3030 St-Joseph Boulevard | Formal Review | Official Plan Amendment, Zoning By-law Amendment & Site Plan Control Application | Mastercraft Starwood, RLA Architecture, Fotenn Planning + Design

SHEET TITLE:
SITE PLAN

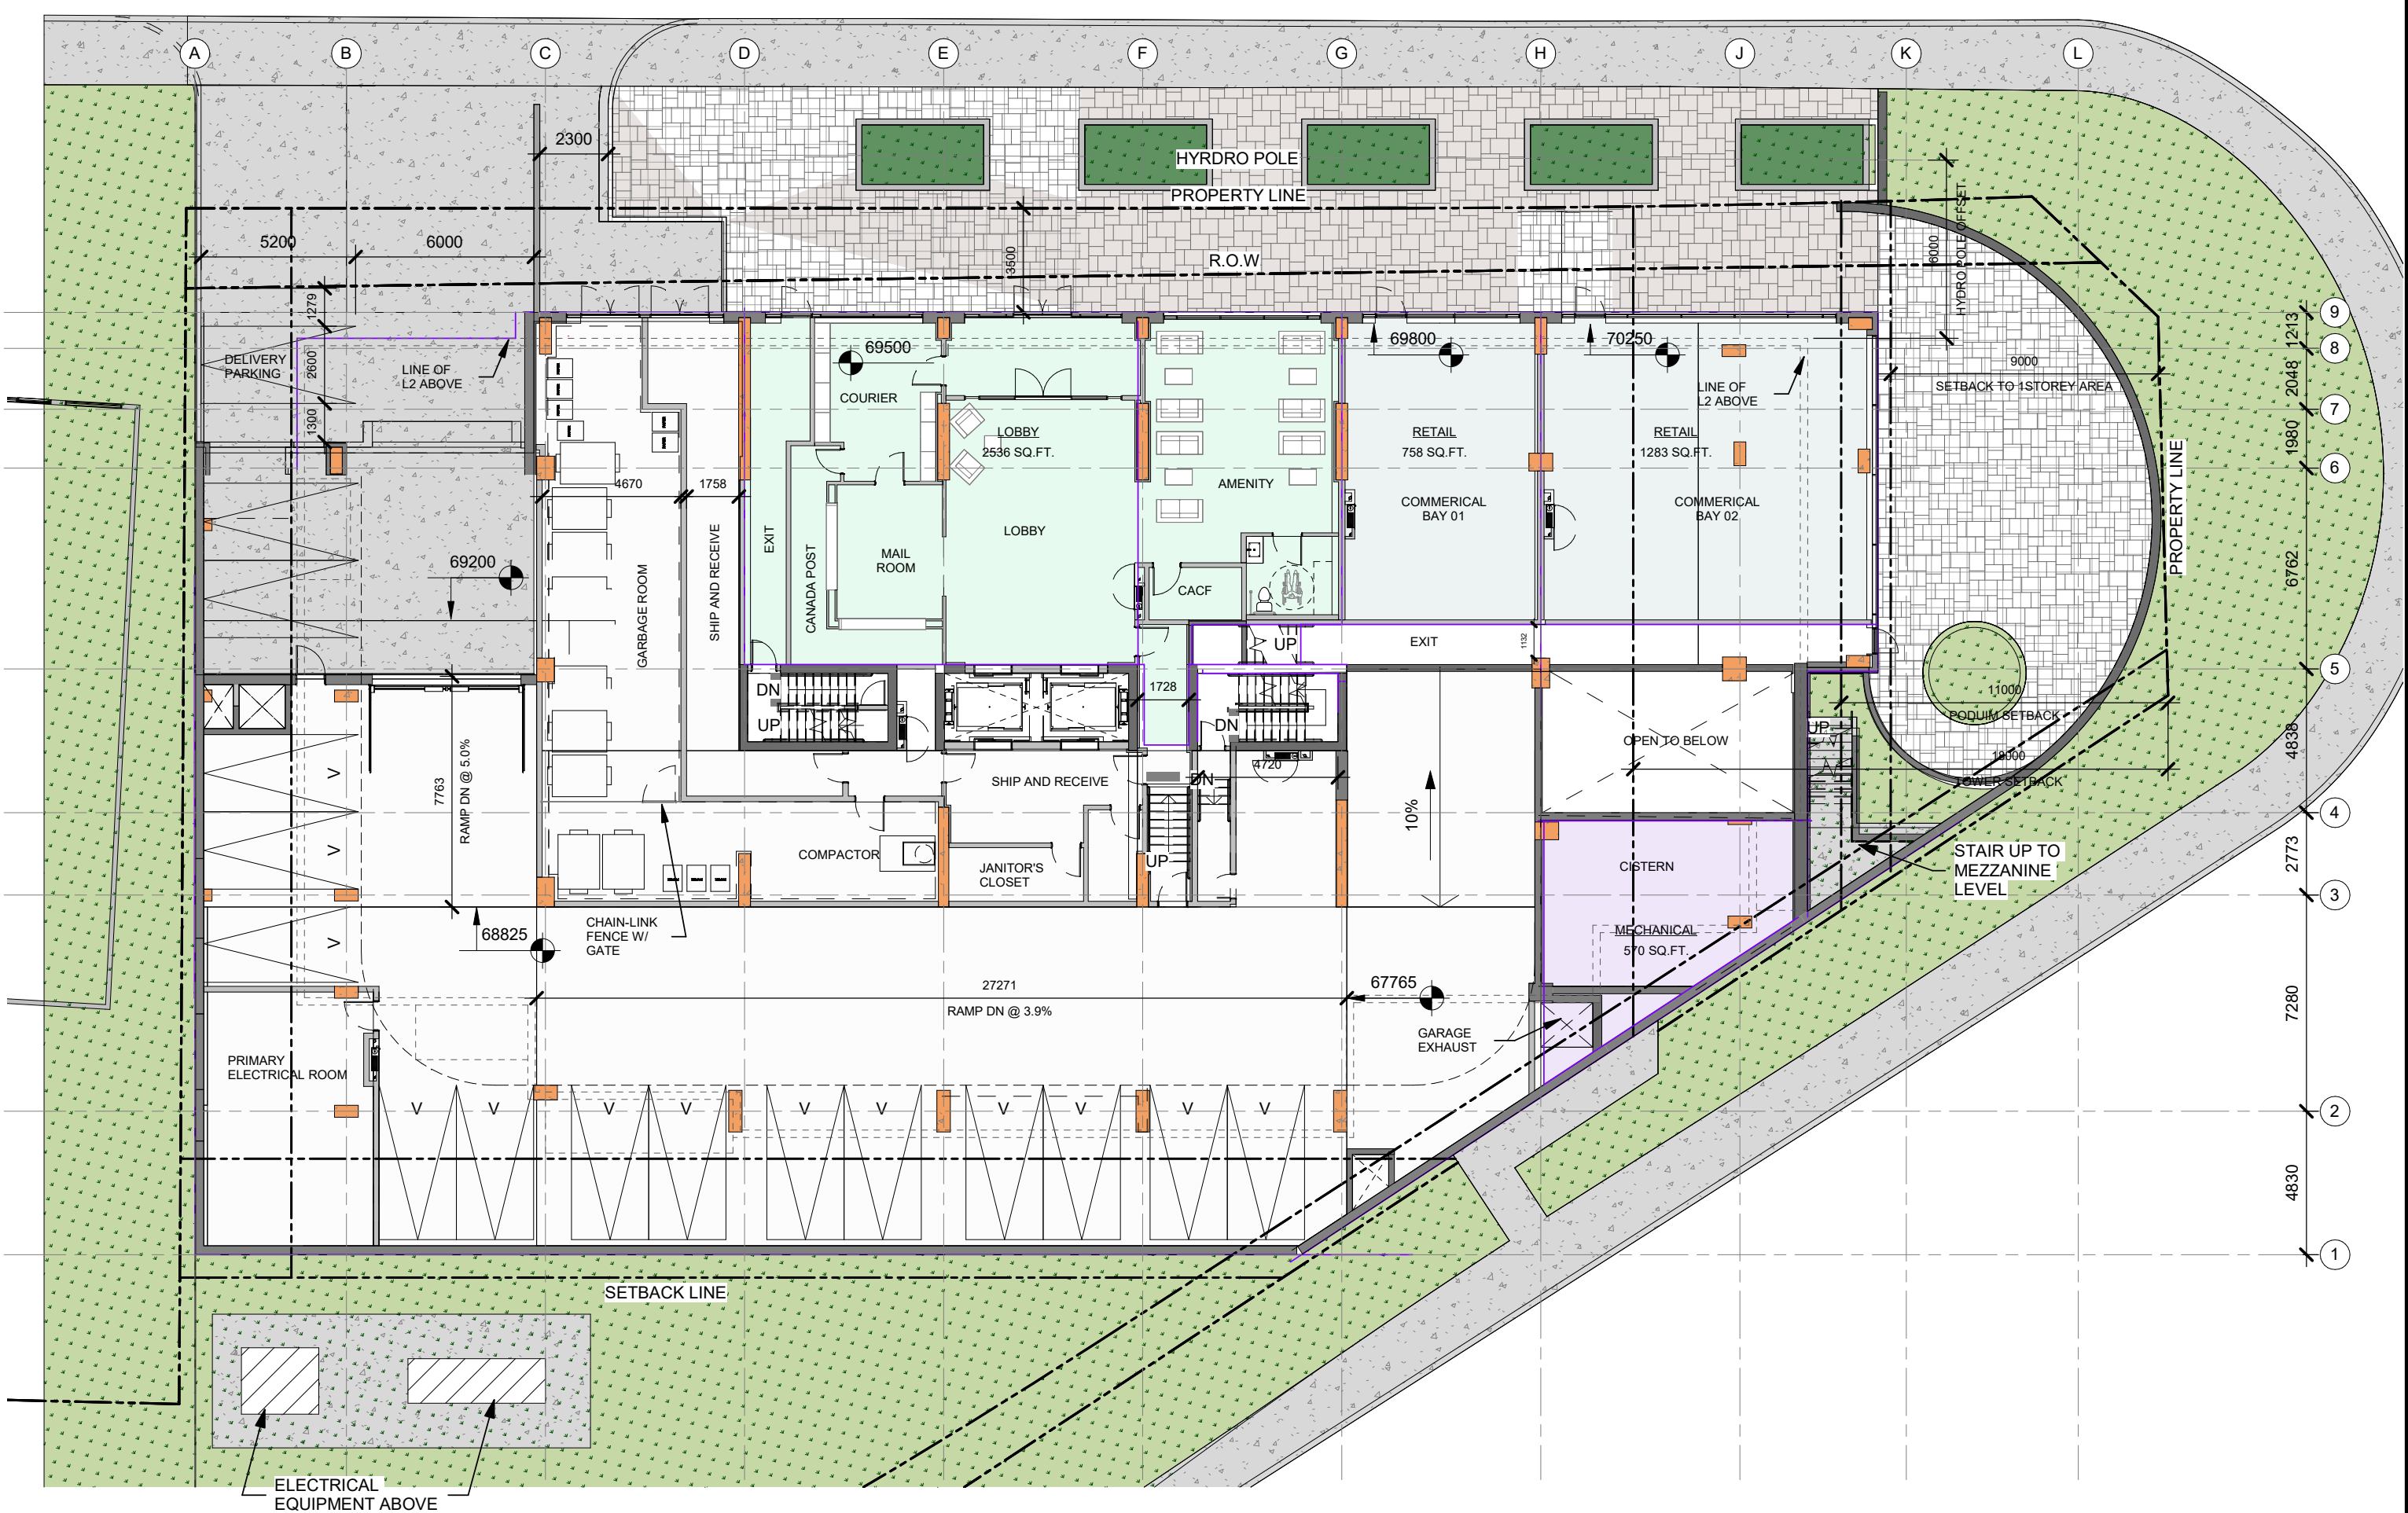
- The Panel strongly recommends opening up the corner plaza element beyond the property line to provide a robust corner POPS/public realm at the intersection of St-Joseph Boulevard and Duford Drive, as previously contemplated in the 2019 UDRP submission.

- Consider including street trees and hardscaping beyond the property line along St-Joseph Boulevard and at the corner intersection.
- The Panel has concerns with the currently proposed curved retaining wall closing the plaza space off from the public.

- Consider opening up the corner plaza element by either extending the retaining wall along Duford Drive straight out to the intersection or by minimizing the location of the retaining wall / seating, which is related to the potential restaurant, creating publicly accessible space beyond.

- The Panel recommends further developing the greenspace on the south side of the building along Duford Drive into a publicly accessed POPS with street trees, seating, and plantings.

- Consider continuing the street tree planting from St-Joseph Boulevard around the corner and up the hill into the neighbourhood along Duford Drive.

ELEVATIONS

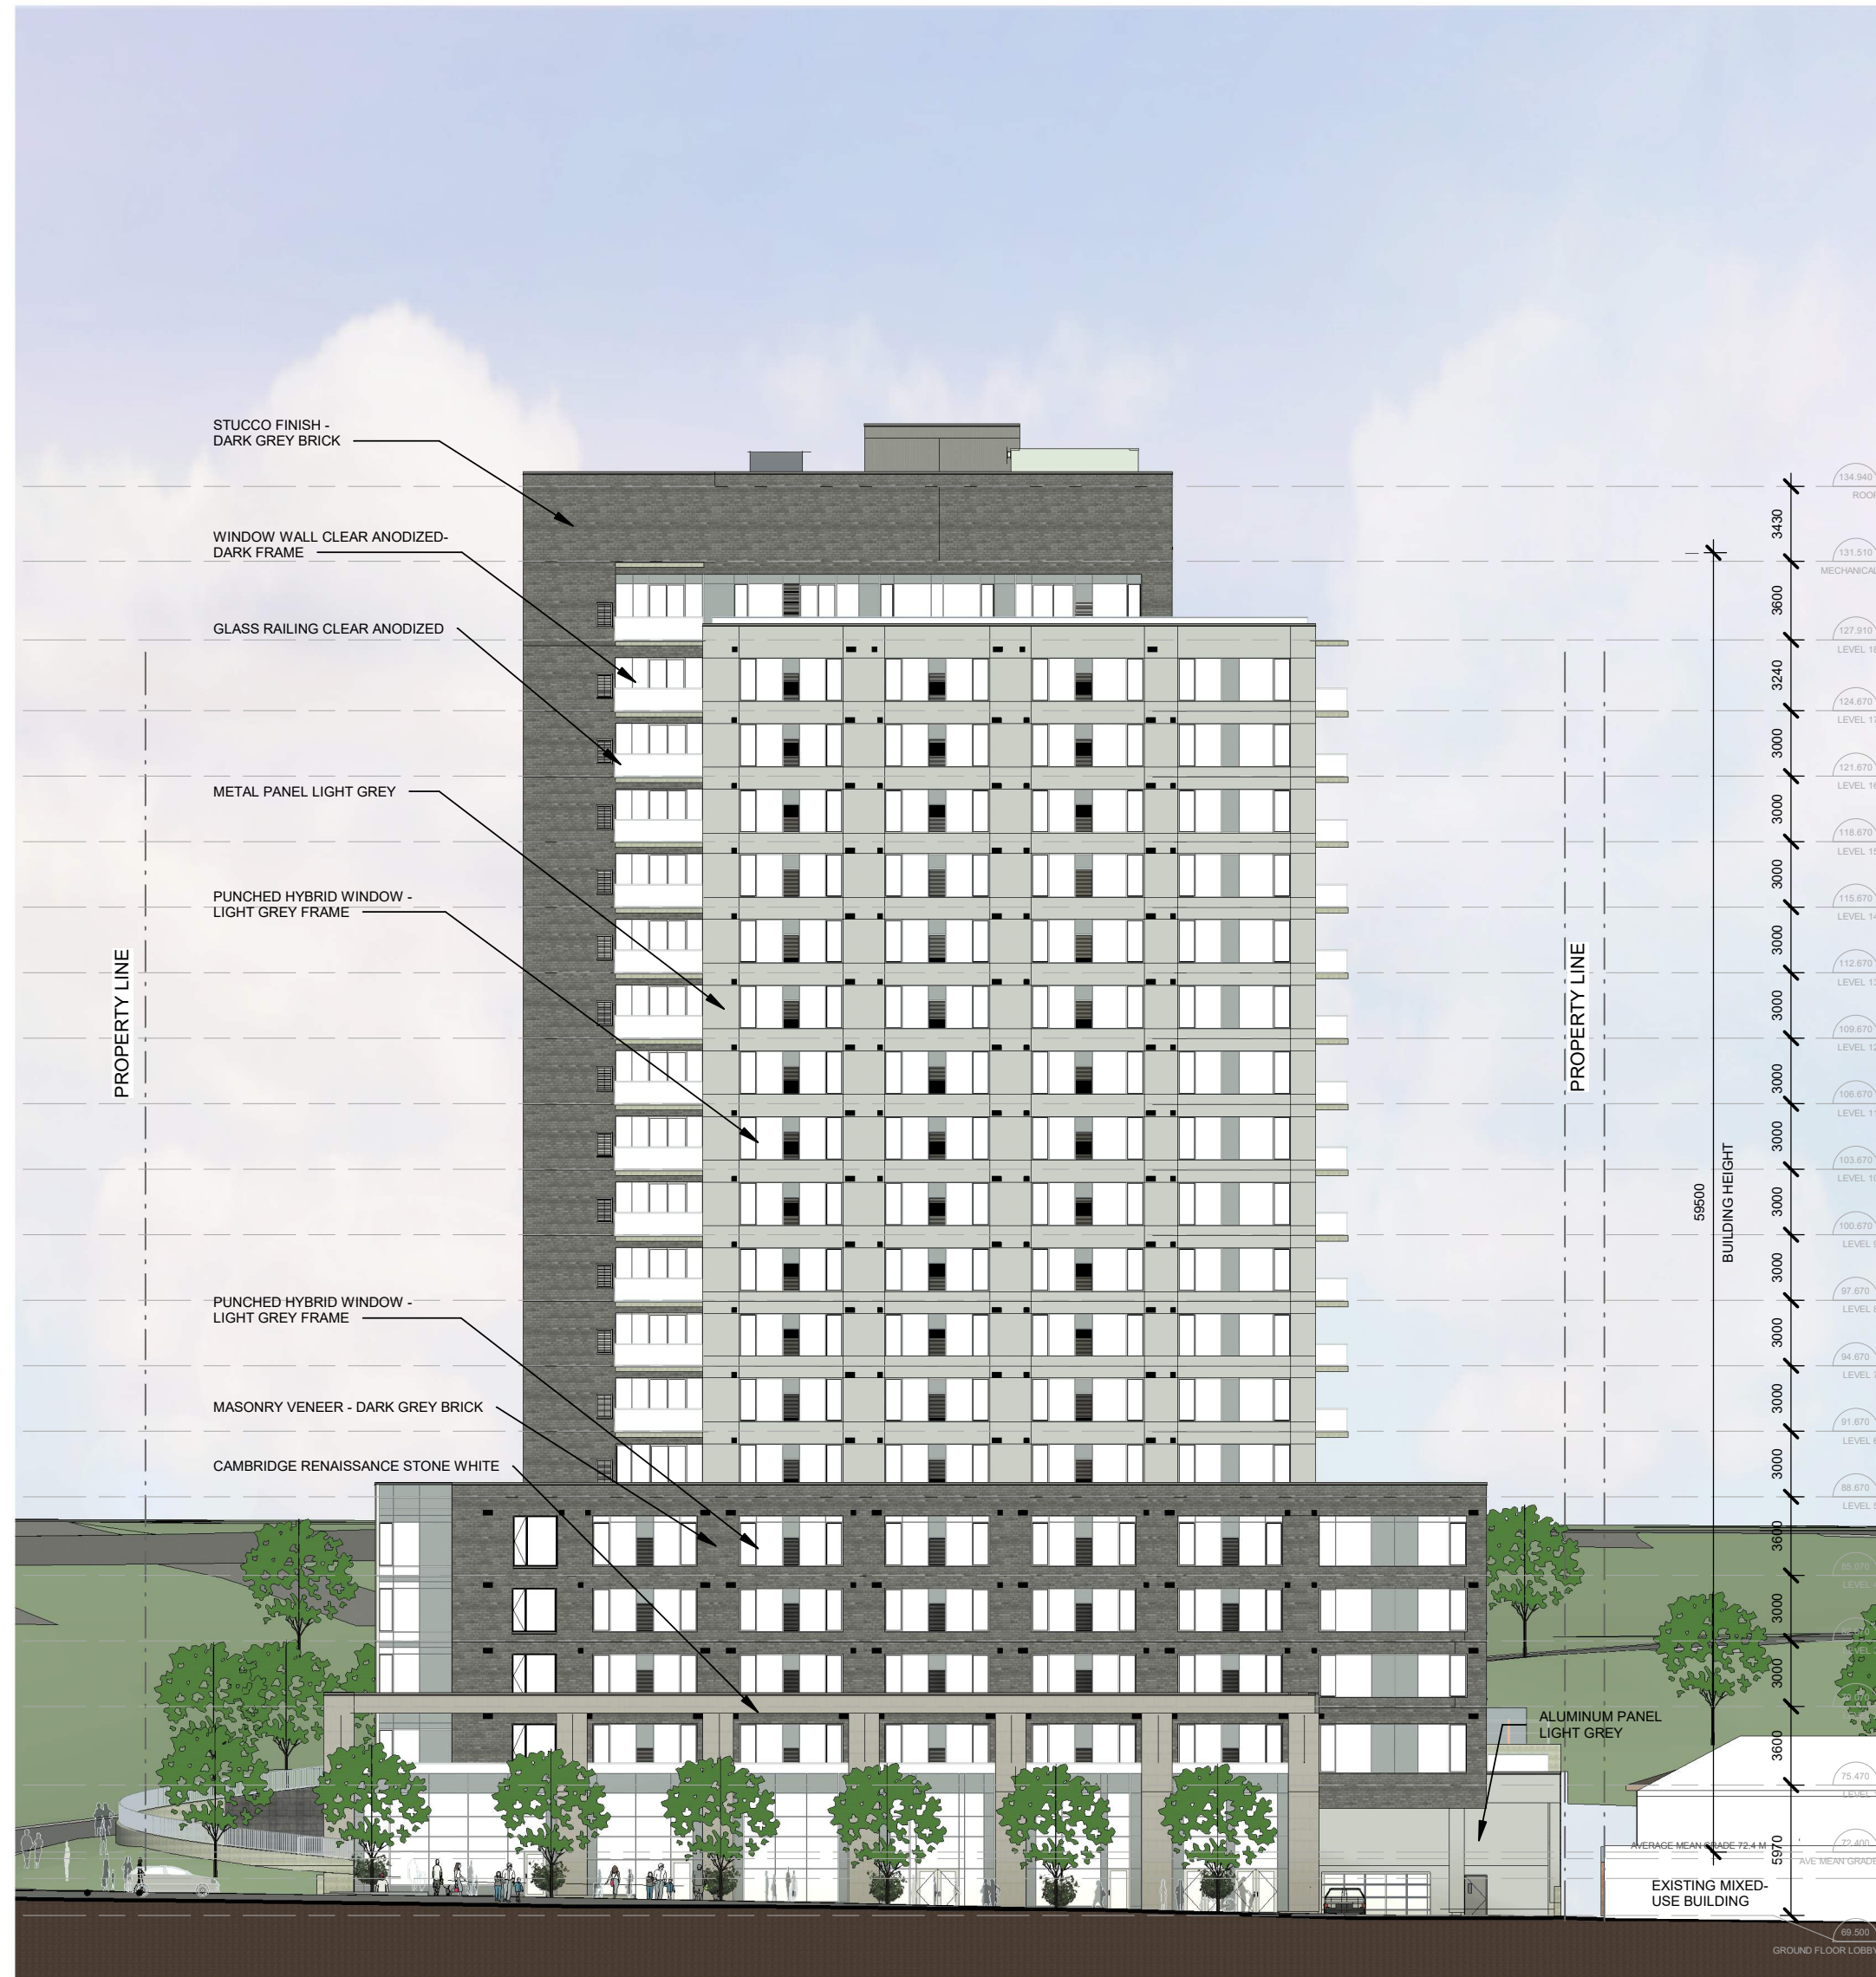
- The Panel recommends refining and simplifying the podium expression by applying a brick materiality rather than spandrels at the north-east and south-west corners of the podium.

- The Panel suggests considering more of a feature architectural element along the eastern edge of the building, potentially referencing the flatiron approach of past renditions.

- The Panel suggests simplifying and selecting a singular cladding material for the backdrop of the proposed eastern plaza space.
- The Panel suggests wrapping the canopy and stone colonnade around the eastern portion of the podium at the corner to give it more depth as a ground level feature.

- The Panel recommends adjusting some aspects of the material palette.
 - The Panel suggests a warmer tone of brick, such as a red brick, at the podium level to further differentiate the massing of the podium from that of the tower portion.

- The Panel recommends further exploring options for articulating the top element of the tower which screens the mechanical penthouse.
 - Consider screening the mechanical penthouse at the top of the tower with a lighter material or architectural element rather than a dark solid brick wall.

- The Panel recommends refining the eastern elevation of the podium, as it is a particularly important view.
 - The Panel suggests the earlier design, which took more of a flatiron approach to the corner element, was more successful at capitalizing on the unique shape of the property parcel and creating a gateway element into the neighbourhood.
 - Consider the importance of that eastern corner view along the streetscape and as a gateway to the neighbourhood up the hill.
- The Panel has concerns with the window-wall element and how it wraps around the corners, both at the north-east corner and the south-west corner of the podium.
 - Consider using the podium brick material in place of the spandrels at both corner locations.
 - Consider bringing the canopy and stone colonnade from the north façade around the eastern portion of the podium at the corner.

- The Panel recommends pursuing a more contextual material for the podium than the black brick.
 - Consider red brick, or a warmer tone than black brick, at this site.
- The Panel has concerns with the stark blank walls surrounding the garage entrance area.
 - Consider adding some architectural detailing to the lower 1- or 2-storeys of the building.
